**TREE IMPACT ASSESSMENT – Trees 299 & 373  
Telopea Urban Renewal – Stage 1A, Telopea, NSW, 2117.**

This letter has been commissioned by Frasers Property Australia, to obtain advice about the impact of the proposed building, civil and associated landscaping works on two trees located within the proposed build area.

Masterplan South Precinct - Existing Condition & Demolition Plan

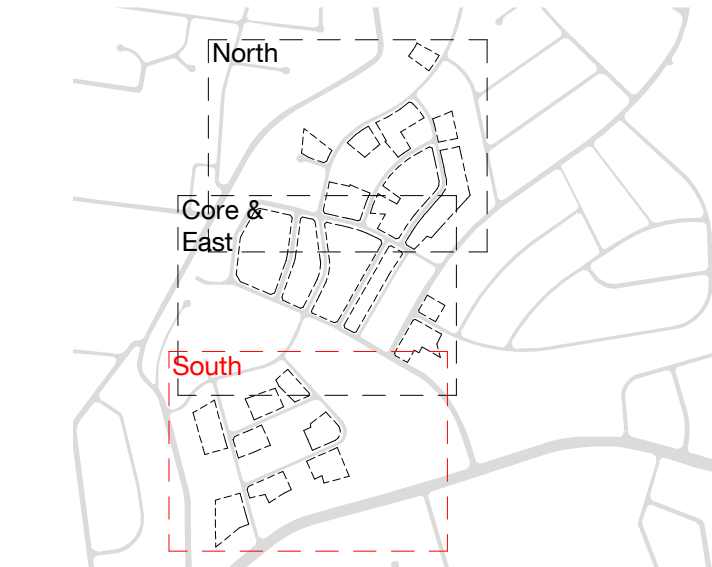
The original arborist report shows that this tree is to be retained with a minor encroachment into its Tree Protection Zone (TPZ) by the proposed construction of the nearby multi storey building. The plan does not however take into account the additional encroachment by the access ramp to the proposed building and the new footpath connection to nearby Winter Street, the new fencing, retaining walls, gate and footpath connecting these points to the other parts of the site. The main footpath is actually positioned within the Structural Root Zone (SRZ) of this tree. These significant level changes, excavation and new hard surfaces will result in a much greater encroachment and could potentially destabilise this tree.

This particular tree, although listed as an A category tree in the above arborist report is in fact a *Cinnamomum camphora* (Camphor laurel) which is a listed weed in NSW and is in fact exempt from protection under Parramatta Councils Development Control Plan (2023) IF it is within 5m of a sewer, pool, or existing building.

It is my opinion that the proposed works will result in an unacceptable encroachment into the TPZ and SRZ of this tree, and it is likely that it will enter a state of decline or even die due to the installation of the proposed works. It is therefore my recommendation that the tree be removed and replaced with a replacement tree of a more suitable species.

The original arborist report also shows that this tree is to be retained with a minor encroachment into its Tree Protection Zone (TPZ) by the proposed construction of the nearby multi storey building. The excavation for the proposed basement has been located outside of the TPZ for this tree, however the building at ground level will result in this minor encroachment. The arborist report also briefly shows some extra works within the TPZ but does not discuss them.

In the case of this tree, the additional encroachment is mainly some concrete and stone paved pedestrian pathways and are strategically located outside of the Structural Root Zone (SRZ) of this tree. It can be said that the stone pathways could be constructed above grade, using tree sensitive construction methods to further reduce the encroachment and therefore impact on this tree.

This particular tree, a *Ficus macrocarpa* var. *hillii* (Hills Weeping Fig) is considered to be a species with a very extensive root system, which is very unlikely to be affected by this

level of encroachment. Some basic remediation works such as thickly mulching the TPZ and applying regular water before, during and after the development works will ensure that this tree can be successfully retained with minimal adverse effects.

It is my opinion that the proposed works will not result in a significant long-term impact on this especially if tree protection is carried out as per the tree protection methodology set out in the above report. This tree can be successfully retained and protected under these proposed plans.
